**Re: Whataburger 2141 Gibson Blvd SE
Erosion and Sediment Control Plan
Engineer's Stamp Date Missing (M15E021A)**

Based upon the information provided in your submittal received 2/17/2023, the above-referenced ESC Plan cannot be approved for Building Permit until the following comments are addressed.

STORMWATER
POLLUTION
PREVENTION PLAN
PHASE II (INTERIM)

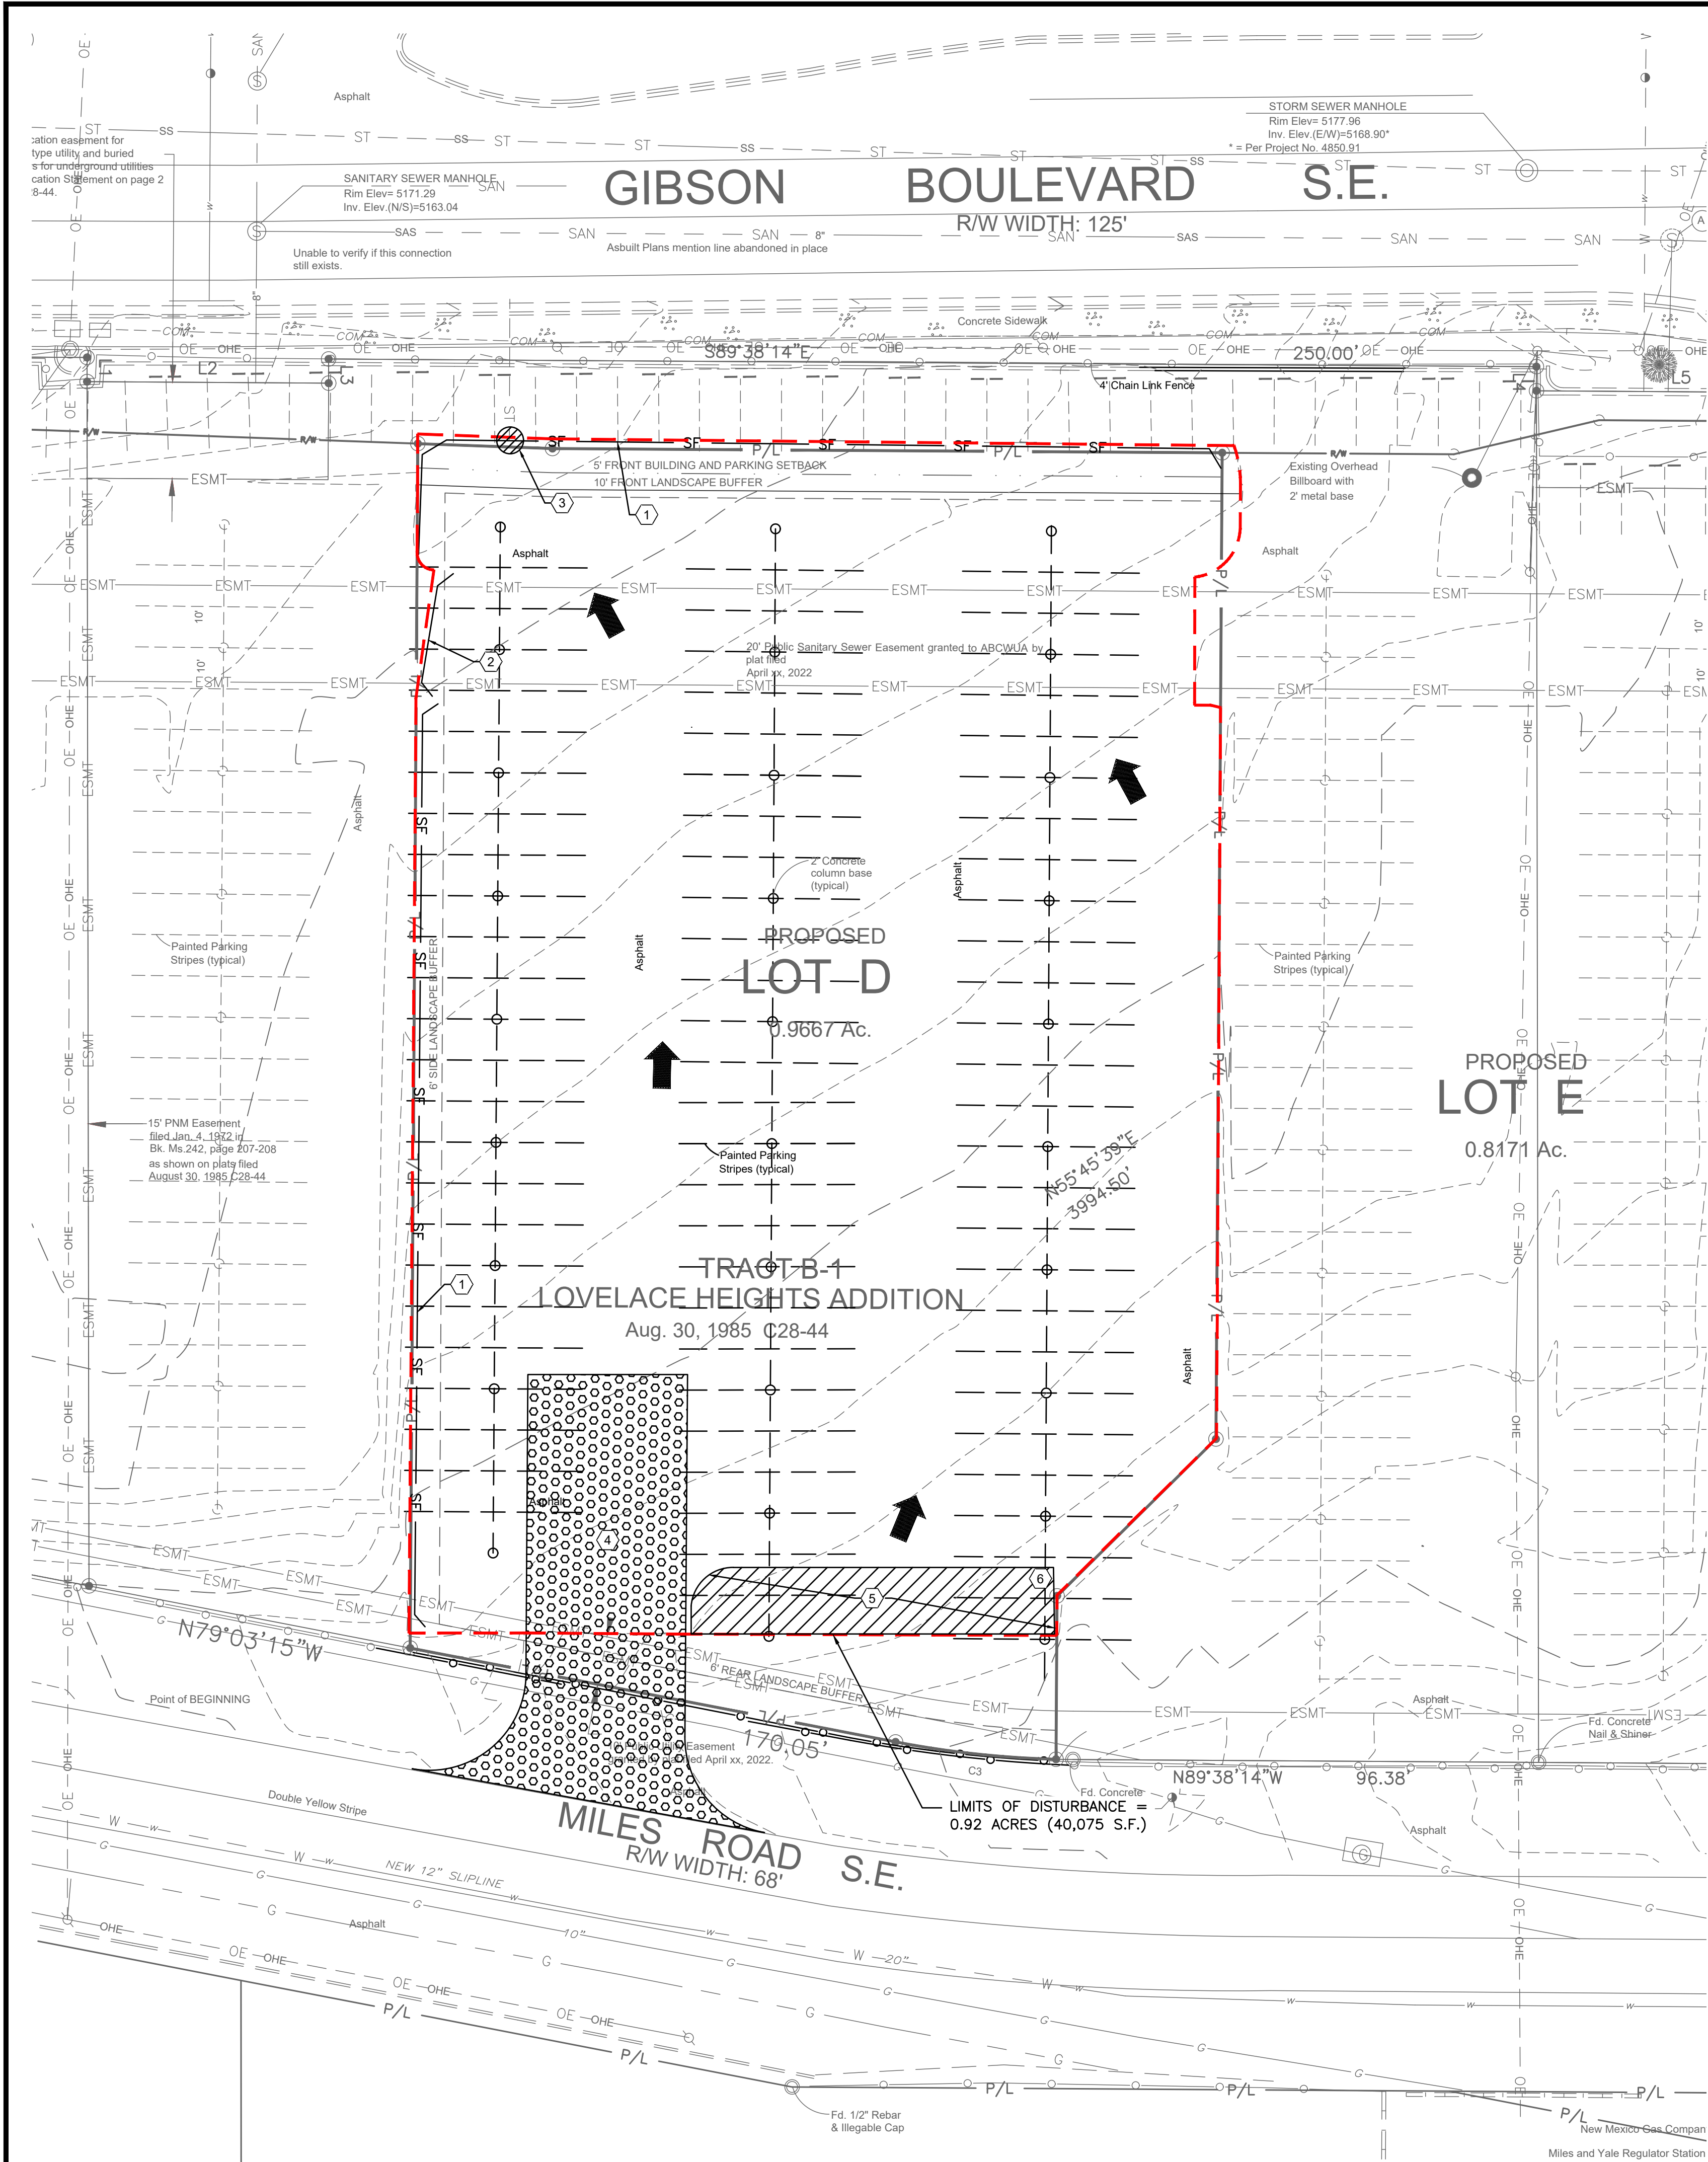
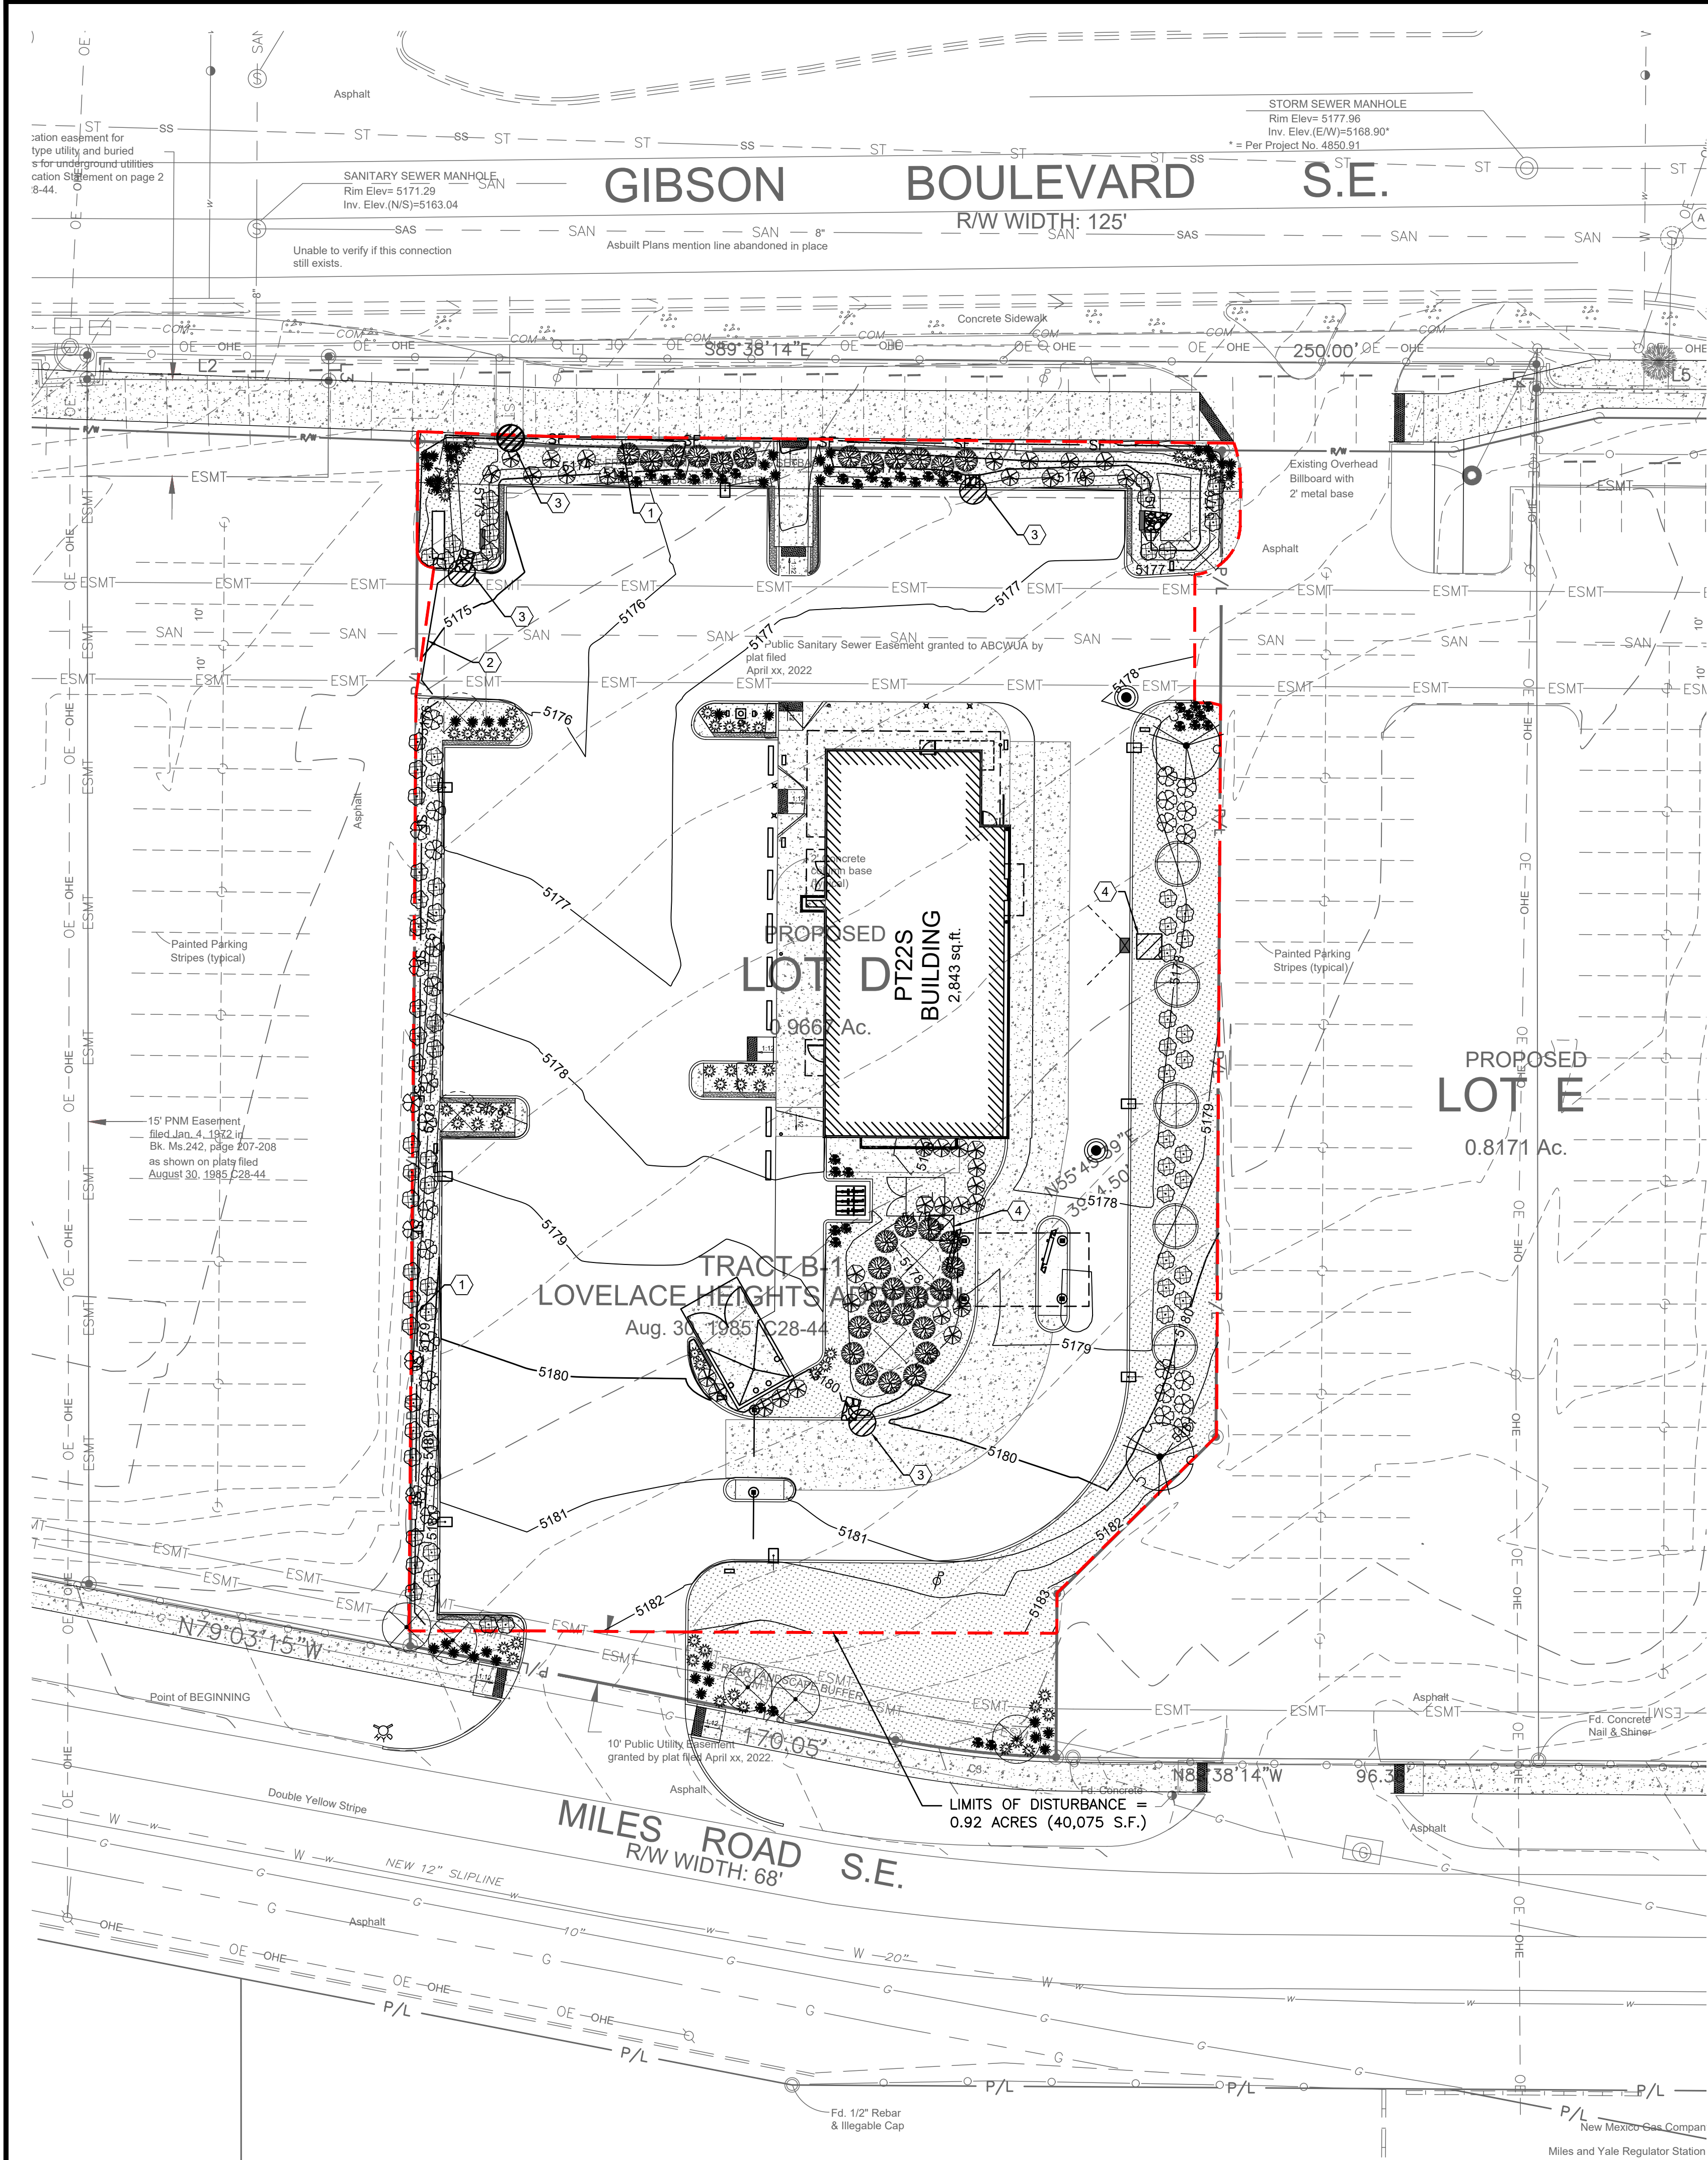
1. The ESC Plan must be certified by either a Professional Engineer (PE) or a Certified Professional in Erosion and Sediment Control (CPESC). Update the engineer's stamp date each time the plan is changed.
